Martin Nugent
01254 828060
D3/12/0014

**Outline Planning Application, Ribble Valley District
D3-12-0014 land adjacent to Greenfield Avenue, Low Moor, Clitheroe**

I refer to your letter of 5 April 2012 concerning the above application.

Drg N^o
370/1/2
Rev. A

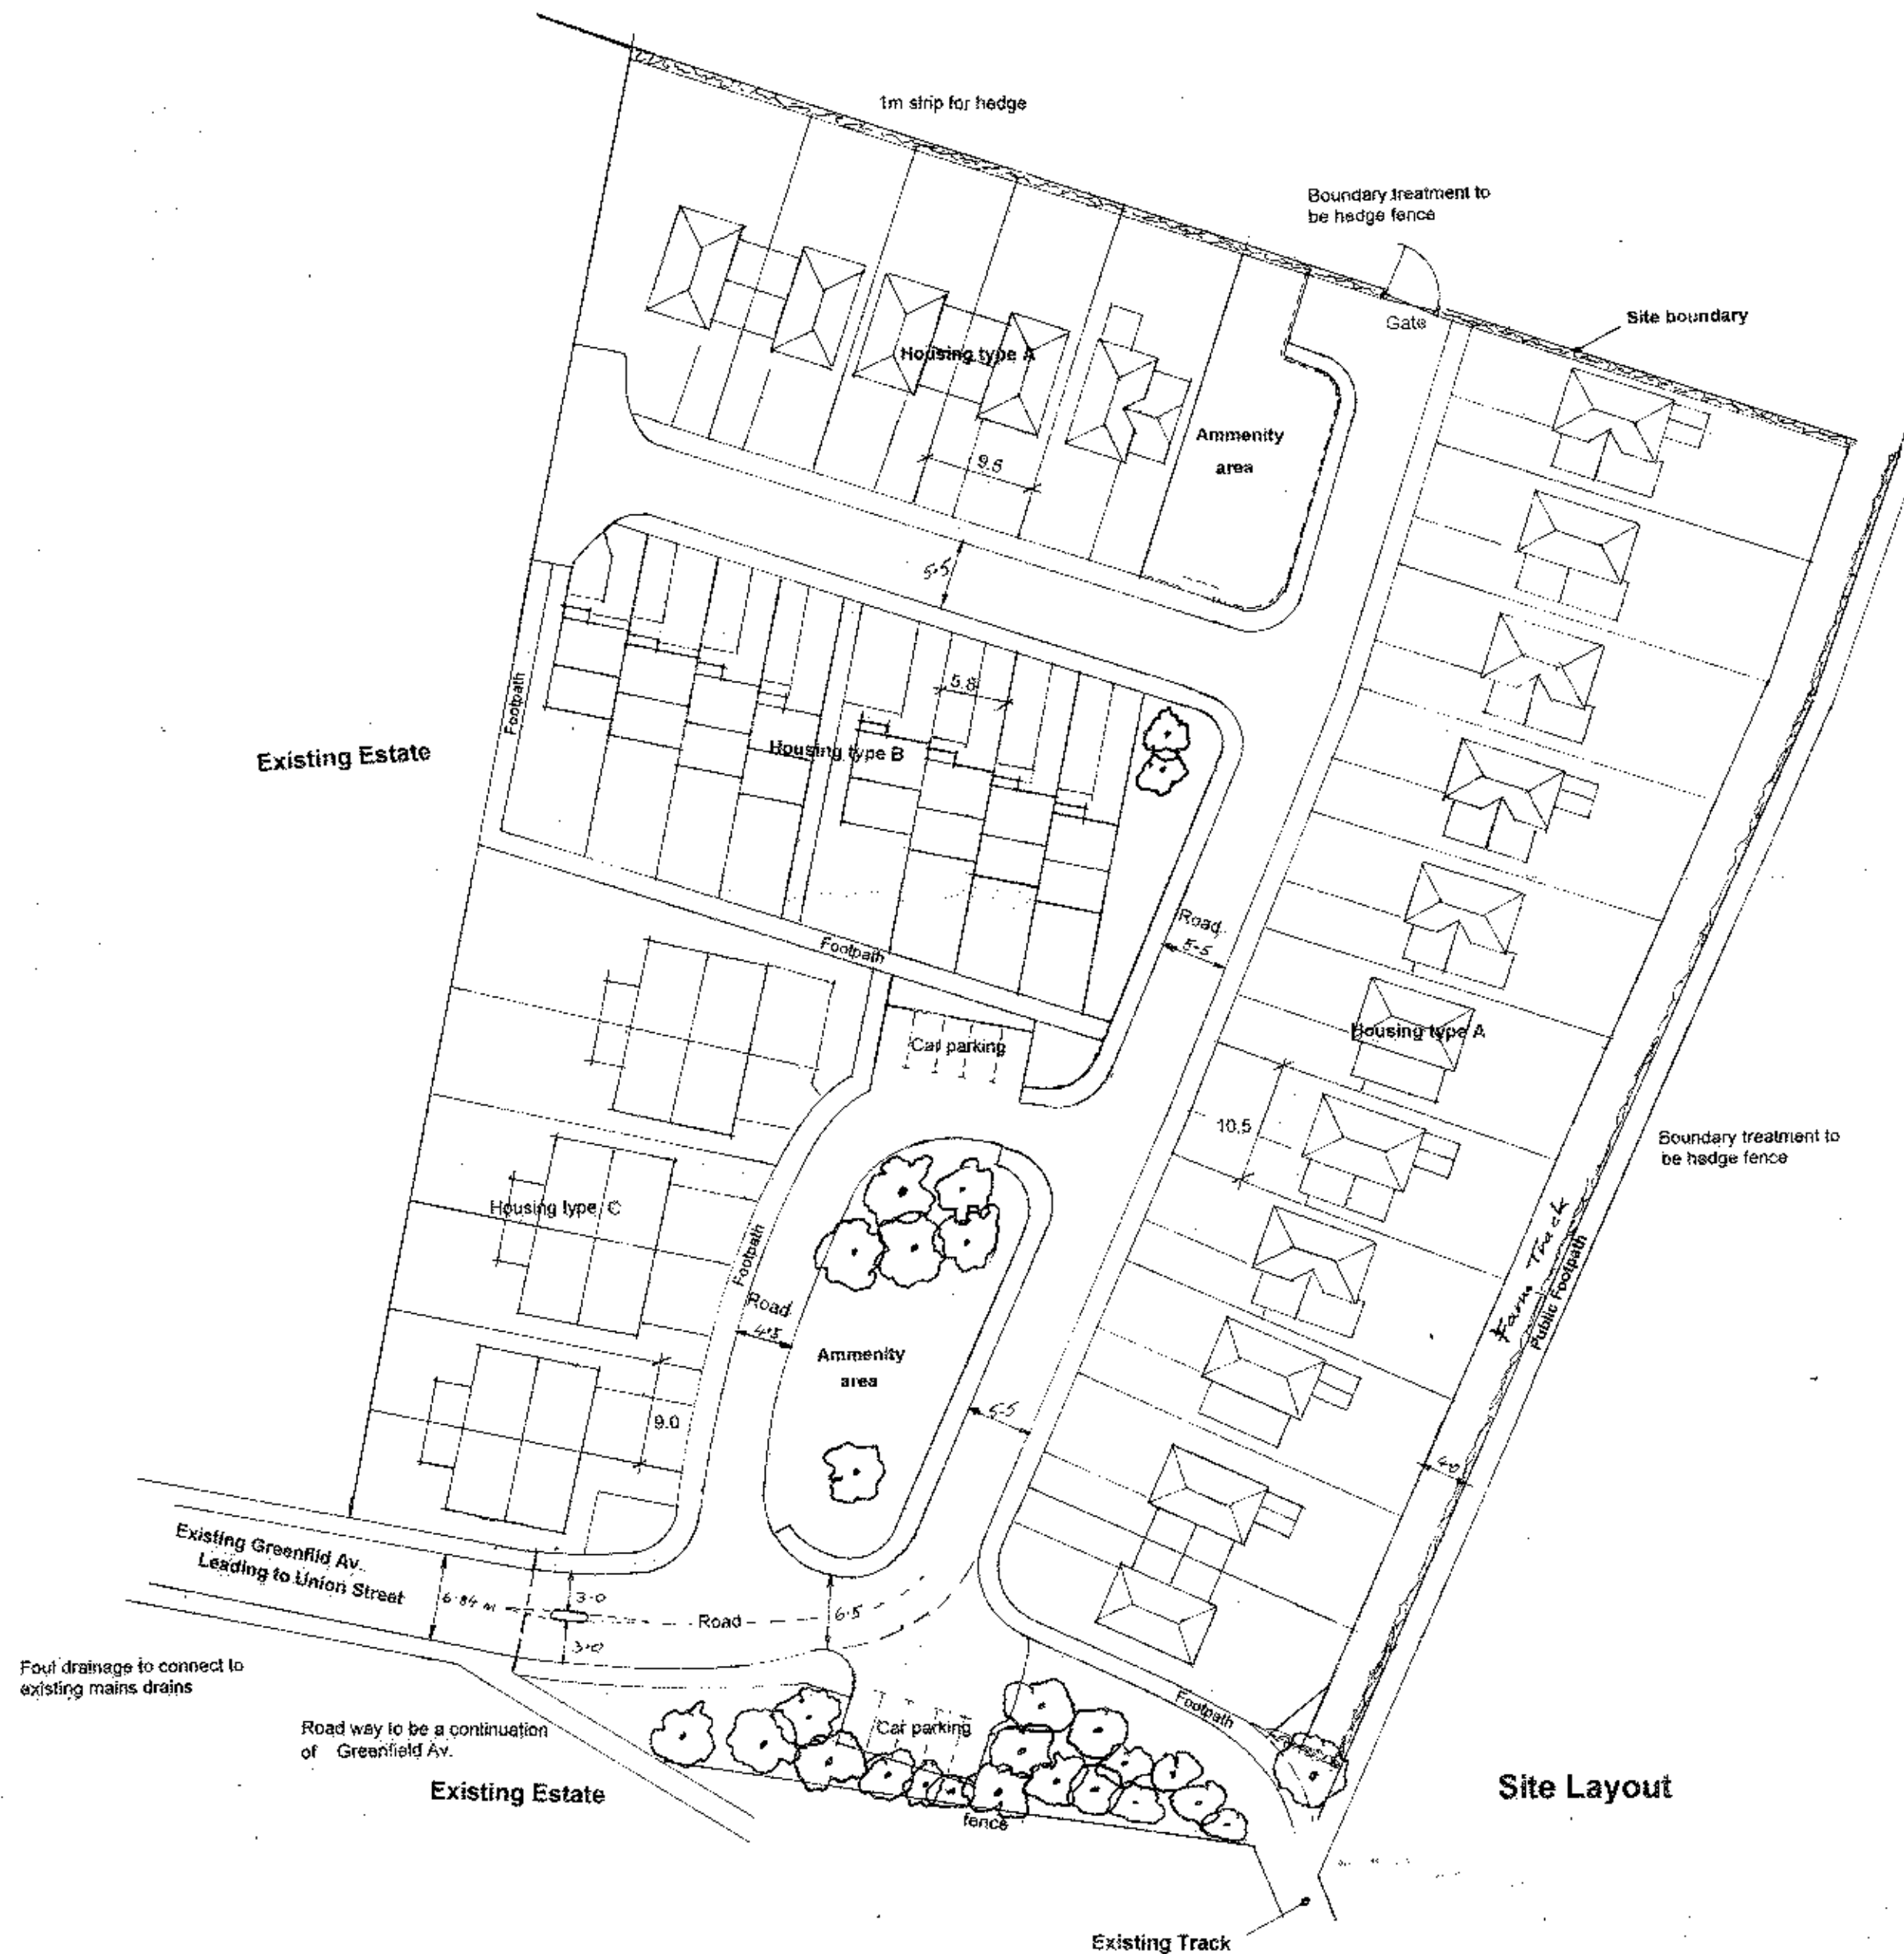
The vehicular access to the site will be extended from Greenfield Avenue onto the development site. The design contained in Drawing 370/1/2 provides an indication of the highway parameters for the design of a suitable vehicular access.

In order to secure appropriate measures to enhance safe manoeuvring to and from the site should the application be successful, I would recommend the introduction of junction markings at Queens Street and Greenfield Avenue on any subsequent site plans. This would establish the correct priority working at this junction.

However, there are some aspects of the initial site layout that should be revised to enhance highway safety.

1. Reduce the carriageway width from Greenfield Avenue (6.84m) onto access road (shown as 7.0m). For the scale of development being considered a carriageway width of 5.5m is sufficient. The use of a 7.0m carriageway width would encourage on street parking and provide for an unnecessary crossing width.

2. The larger amenity space is in an isolated location, requiring pedestrians to access the site across service roads.
3. A narrow service road (3.6m) provides two-way access for 6 properties and additional amenity car parking for 5 vehicles. Utilising the reduced carriageway width identified above in Item 1, the width of the service road could be increased to 4.5m, sufficient for the safe two-way movement of residential traffic.

4. Consider the introduction of a narrowing feature to draw the carriageway width down from 6.8m on Greenfield Avenue into the site, with a 5.5m width.

5. The provision of continuous footway links through the development is welcomed. These footways should be a minimum width of 1.8m throughout.
